**Marine
Management
Organisation**

MMO Reference: DCO/2021/00004
Planning Inspectorate Reference: TR030007

Planning Act 2008, Immingham Eastern Ro-Ro Terminal

This document comprises the MMO comments in respect of the DCO Application submitted in response to Deadline 1.

**IMMINGHAM EASTERN  
 RO-RO TERMINAL  
 INDICATIVE AREA  
 OF CAPITAL DREDGE**

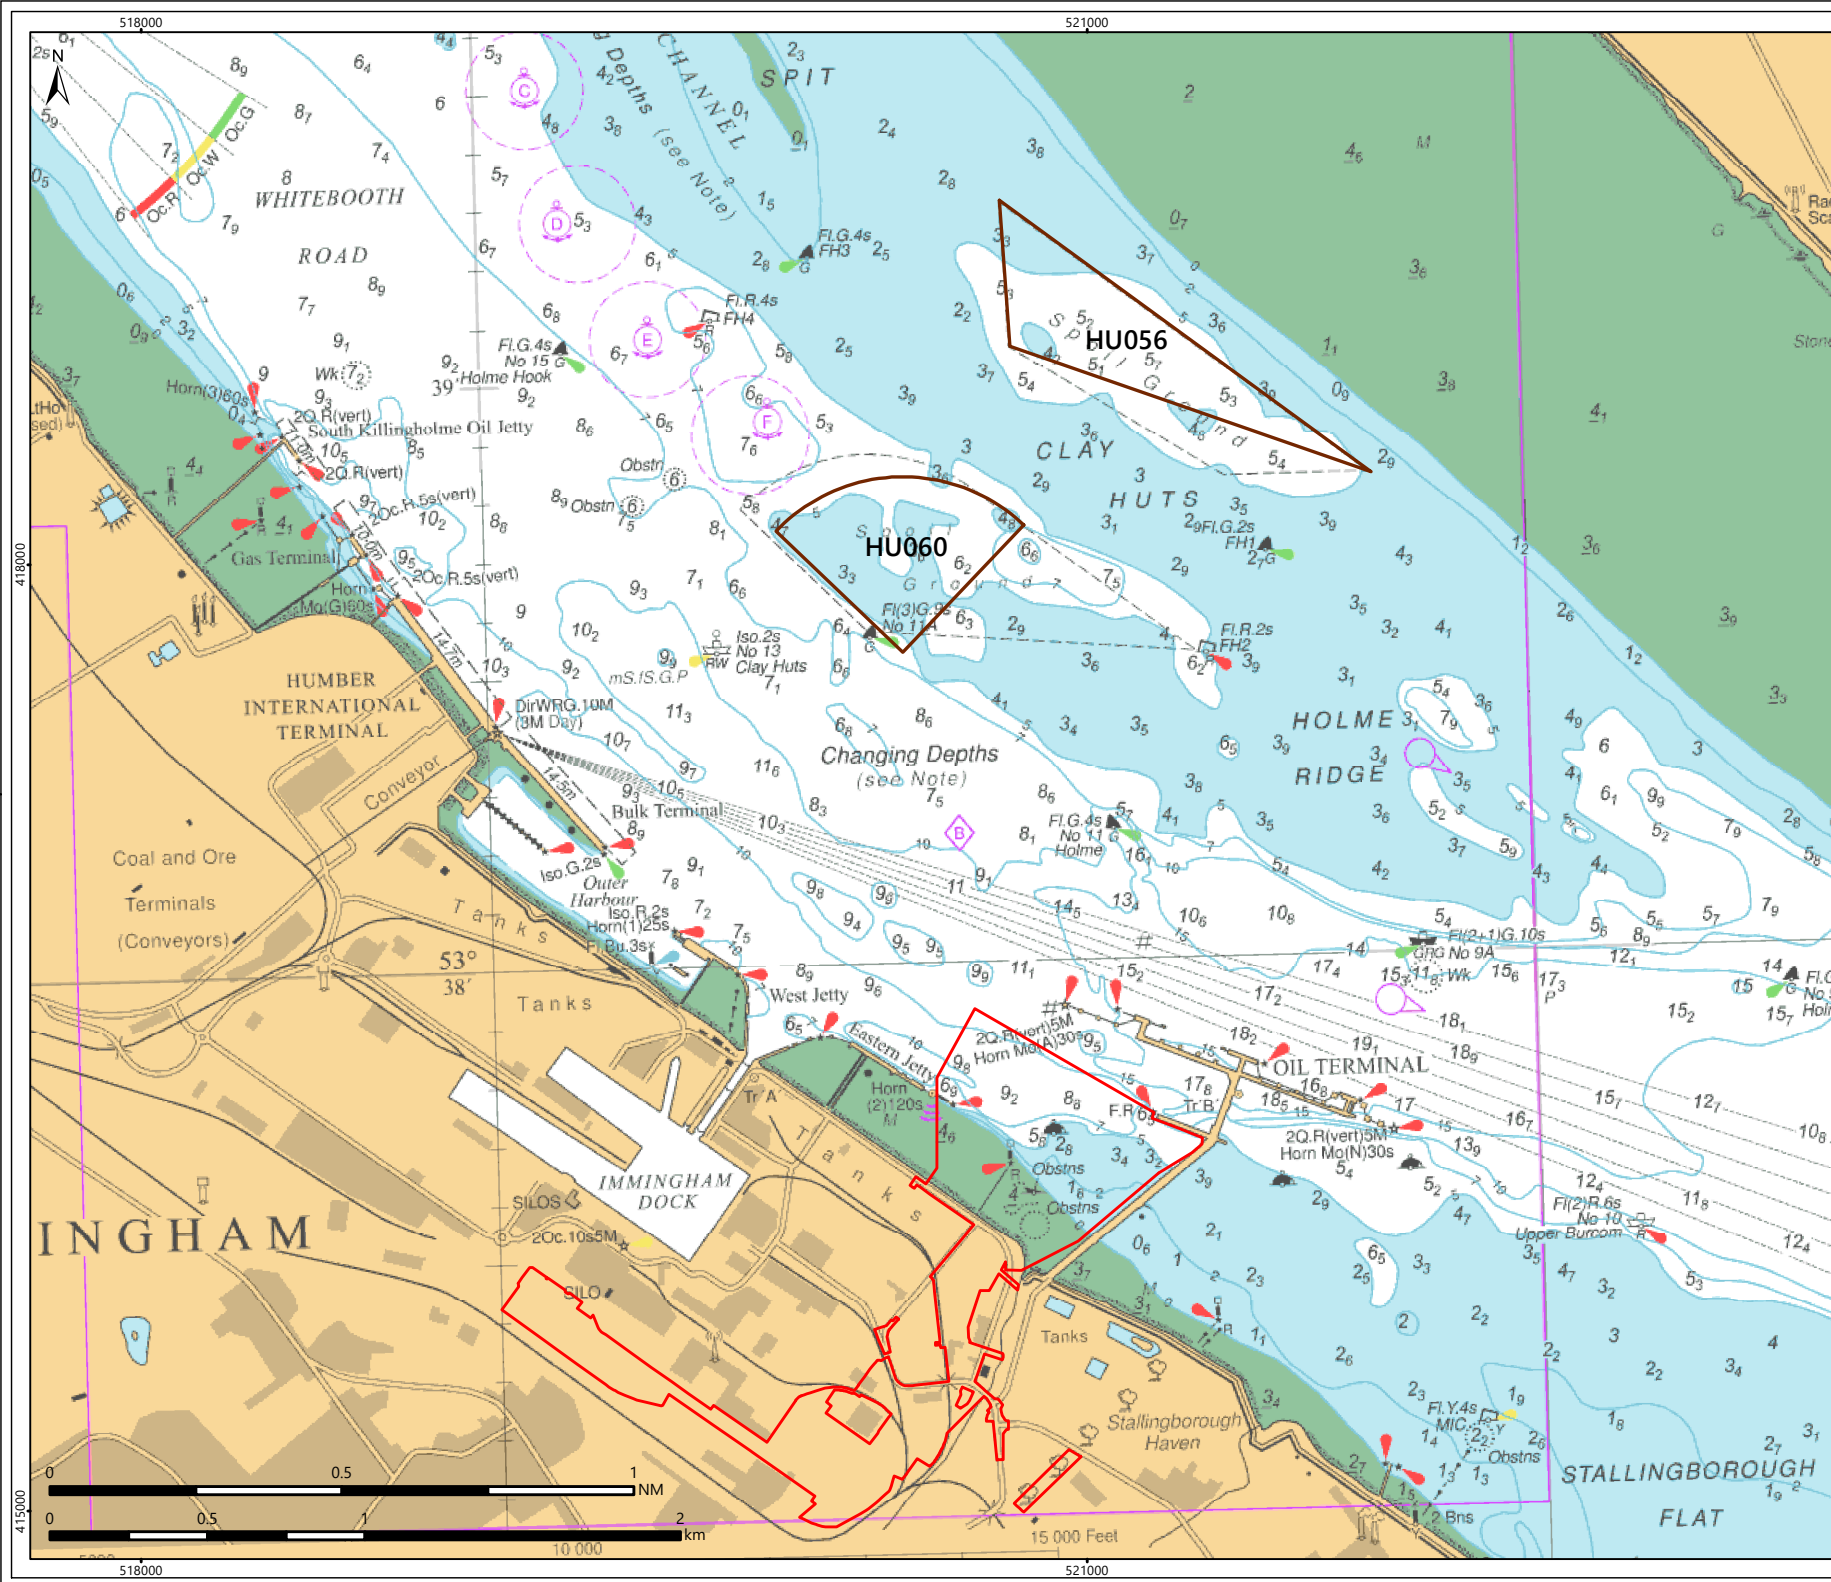
ExQ1	Question	MMO Response
BGC.1.9	<p>Disposal at sea of dredged material The CEMP [paragraph 1.3.9 in APP-111] states "... <i>it is considered that the dredge material is suitable for disposal at sea</i>". Would the MMO confirm whether it does or does not agree with that statement.</p>	<p>Following our review, the MMO has the following comments to provide on the quality of the sediments:</p> <p>The levels of trace heavy metals observed indicate levels to be around or below their respective Action Level 1 (AL1) and are not of concern when considering the quality of the material for disposal to sea from this area.</p> <p>The levels of organotins (di and tri-butyl tin) indicated are predominantly below the limit of detection, or, where detected, are below the AL1 for these contaminants and would not preclude the material from disposal to sea.</p> <p>Levels of polybrominated diphenyl ethers (PBDE), were seen to be high for BDE 209 and BDE99 at sites 1, 5 and 6 at the surface and 1m depth. At sample site 9 the levels were observed to be high to a depth of 2m. Using a pre-industrial baseline, levels of these man-made contaminants would be anticipated to be zero (i.e., there are no background levels of these contaminants in the marine environment), With the exception of area 9 to a depth of 2m these sediments would be considered acceptable for disposal to sea. It should be noted that for the assessment of these results an average estimate of 2.5% organic carbon was used to normalise the data as per best practice under OSPAR (Dr J Barber, <i>pers comm</i>). If the Applicant has results for organic carbon data for these samples, then the normalised levels could be different to the raw data and thus our conclusions could change. Currently there are no agreed ALs in England for PBDEs, and so consequently the best available information has been used to determine whether levels are high or low and for reference have considered the proposed ALs as described by Mason <i>et. Al.</i> (2020).</p> <p>Polychlorinated biphenyls (PBC) levels for the ICES 7 and sum of 25 congeners were observed to be above AL1 for sample 1 and at 1m depth for sample 2 (samples at sites 1, 6 and 7 also contain levels of contaminants above AL1 however</p>

<p>these samples are described as outside of the indicative dredge area). The remaining samples indicated levels below their AL1. Therefore, the material with regard to this type of contamination would be acceptable for disposal to sea.</p> <p>In summary, assessment of the proposed dredge material indicates with the exception of the area around sample site 9 from surface to 2m depth that show what is considered to be high levels of brominated flame retardants, the material is acceptable for disposal to sea. However, there are no current agreed levels in England for action with regard to brominated flame retardants and therefore these comments are advisory only (i.e., not mandated under signatory obligations).</p>
BNE.1.19	<p>Mitigation of suspended sediment impacts on fish species Applicant to clarify whether further assessment and mitigation relating to suspended sediment impacts for fish is proposed, and, if not, why not? What is the MMO's position on this?</p>	<p>Our concerns regarding potential impacts to fish from dredging primarily relate to increased suspended sediment concentrations (SSC) at the dredge site within the confines of the estuary, because high SSC can cause effects in fish such as clogging of gill rakers and filaments, erosion of the mucus coating and abrasion of tissue, increases in respiration and heart rate, as well as reduce dissolved oxygen levels in water, all of which can result in an increase in energy expenditure and reserves and are likely to inhibit migration activities for species such as sea trout and river lamprey as they attempt to negotiate estuarine environments on their upstream migrations.</p> <p>The Applicant has advised that peak SSC of 20,000mg/l can occur naturally in the Humber Estuary, and that the highest SSCs associated with the IERRT dredging and disposal are associated with the disposal activities rather than the dredging and have a predicted peak SSC of 600 to 800 mg/l above background. Given that the predicted peak falls well below the naturally occurring peak (of 20,000mg/l) and is situated at the disposal site, rather than the dredging site within the confines of the river, we are generally satisfied with the Applicant's response regarding effects of SSC from dredging and disposal. It is also accepted that with existing maintenance dredging already taking place in the Humber, coupled with natural fluctuations in SSC, that to some extent, fish migrating through the estuary will have a degree of tolerance to increased SSC.</p> <p>For these reasons, the MMO would not expect the Applicant to carry out any further assessment, as, based on the predicted peak SSCs from dredging, versus naturally</p>
